# ROLLING HILLS RANCH NORTH FILINGS 1 & 2 AT MERIDIAN RANCH PUD DEVELOPMENT PLAN / PRELIMINARY PLAN

PUD DEVELOPMENT / PRELIMINARY PLAN

DATE: 07/07/2023  
PROJECT MGR: B. PERKINS  
PREPARED BY: A. ROMAN

2 OF 16

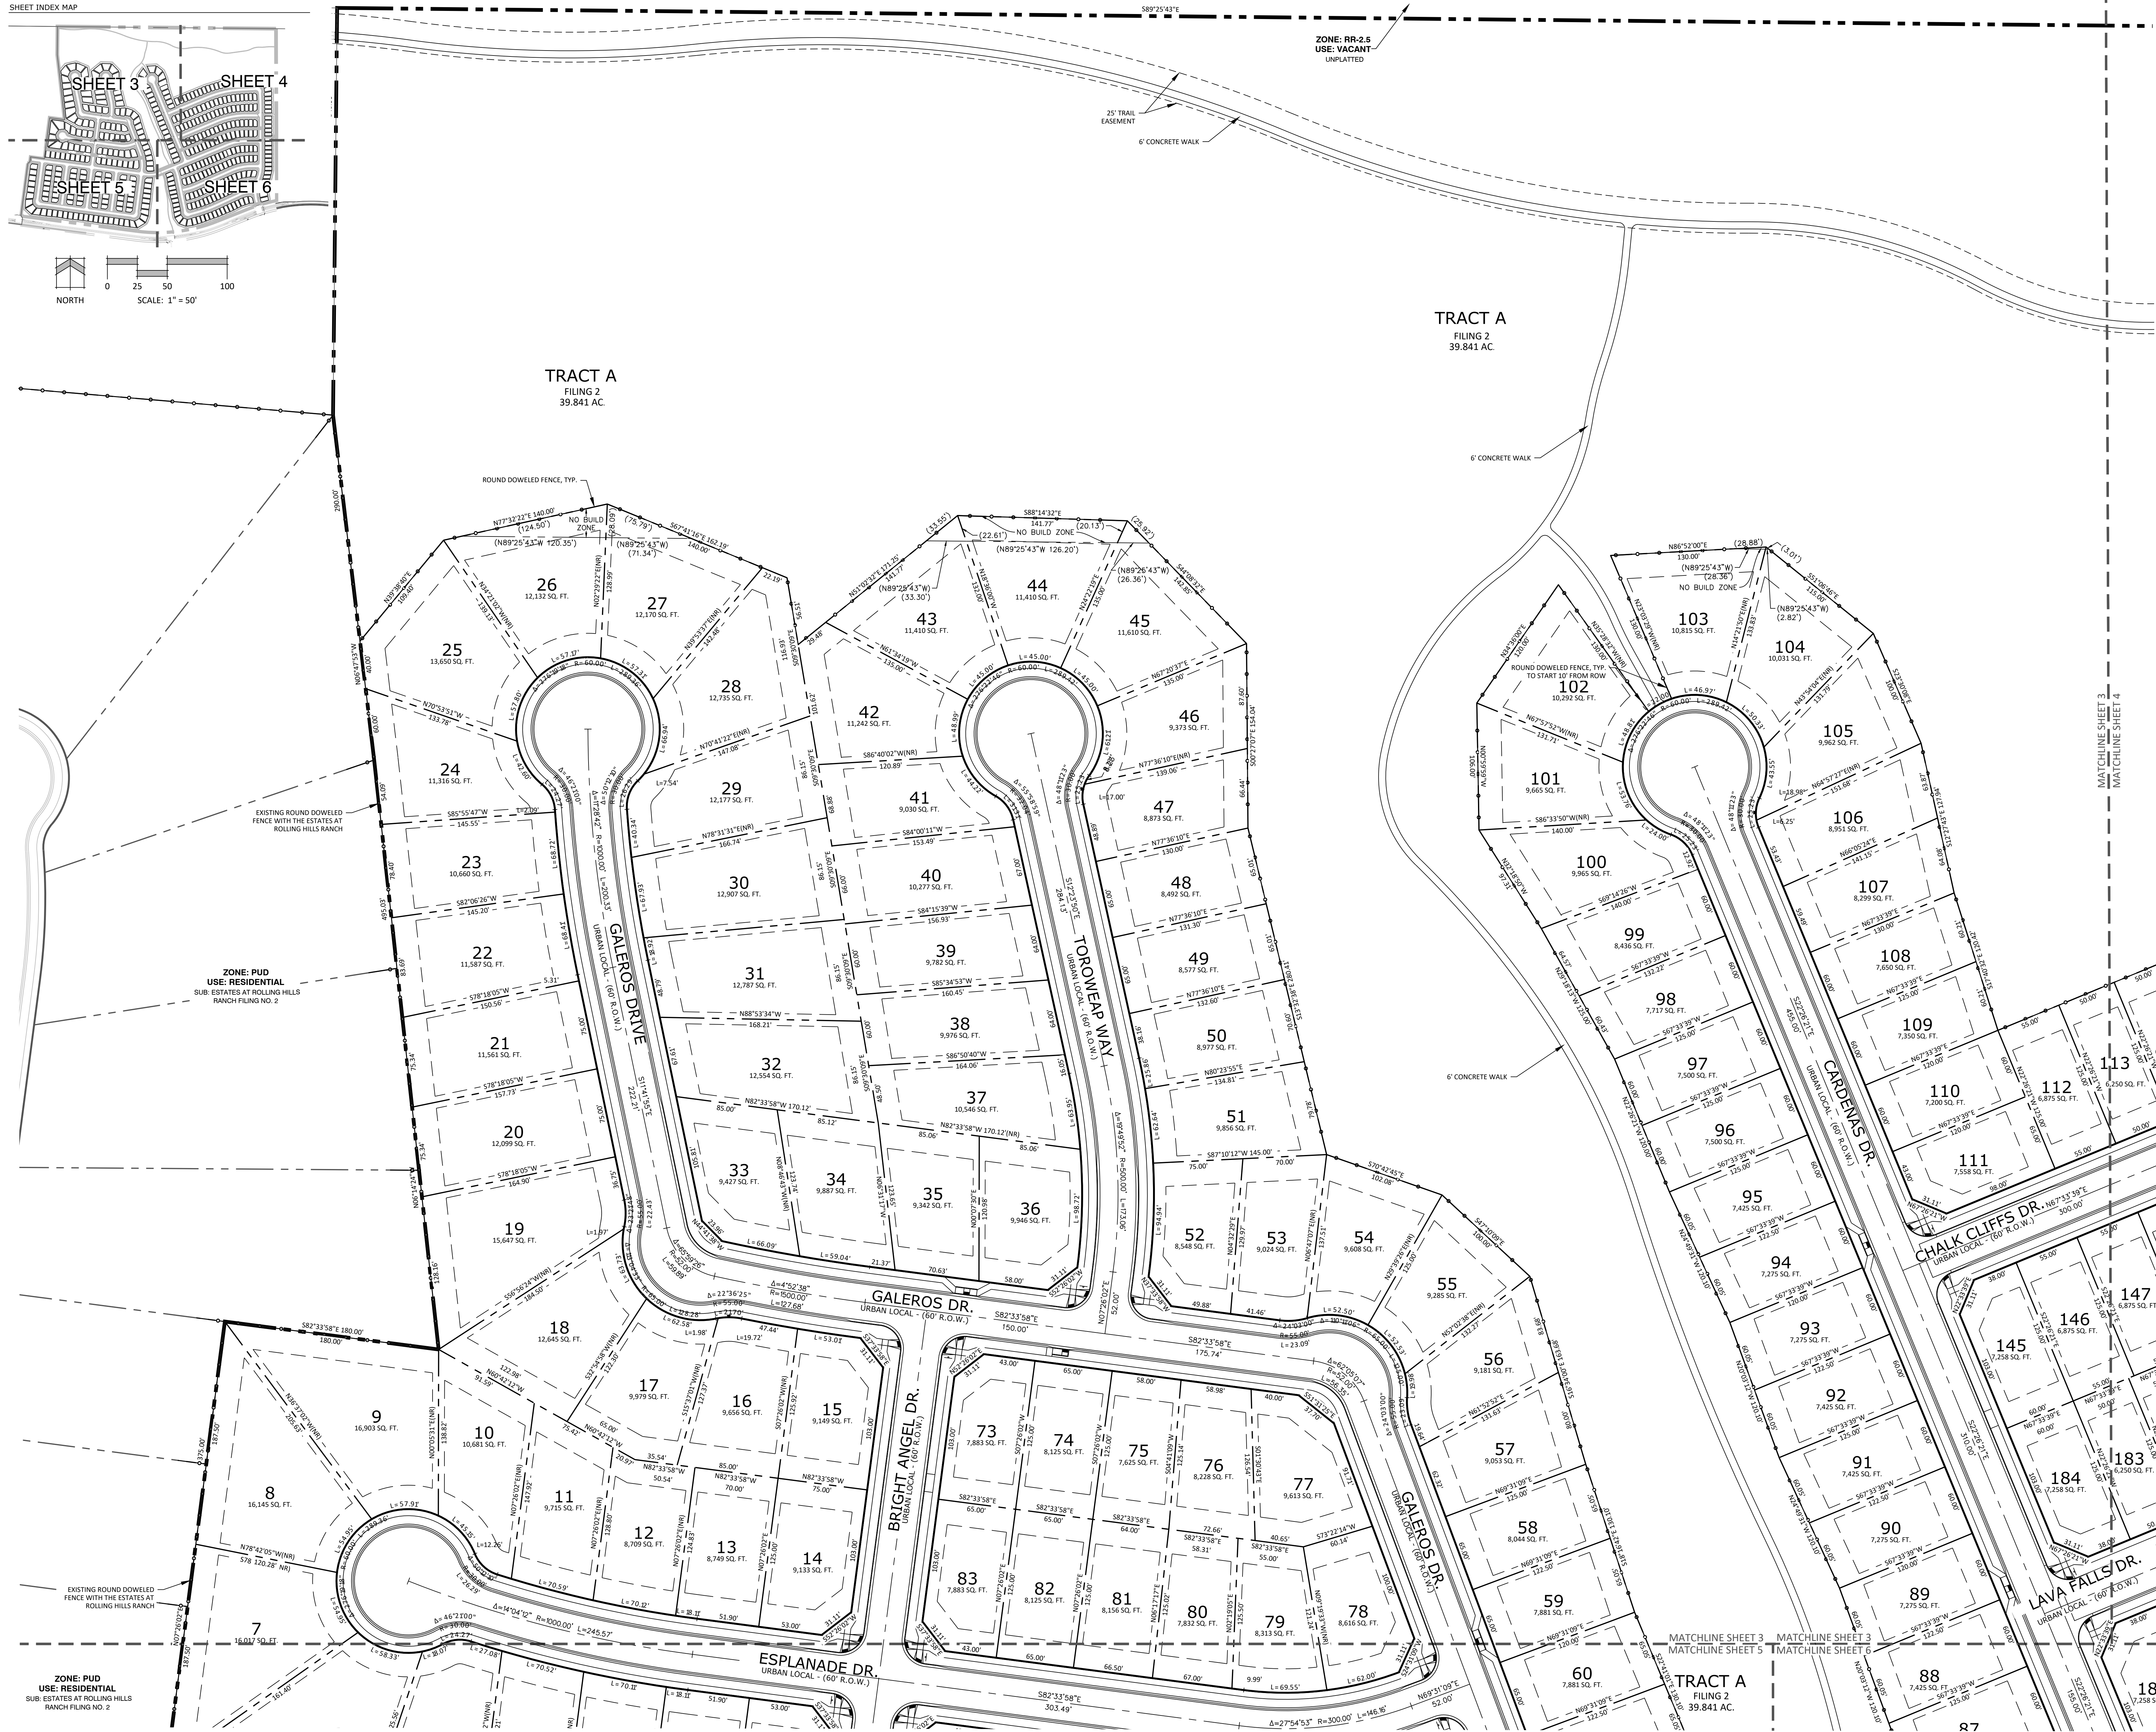
This is a lot of unnecessary information here. This table doesn't include any information that is not provided above in the development data. I would recommend removal of the table to simplify this page.

The overall lot numbering scheme is confusing and difficult to follow. There are duplicate numbers and the numbers do not appear to follow a sequential numbering pattern. If the intent is to provide numbering for Filing 1 and restart the numbering for Filing 2, that's fine, but it needs to be clearly depicted. The numbers need to follow a sequential pattern rather than jumping around.

NES: REMOVED.
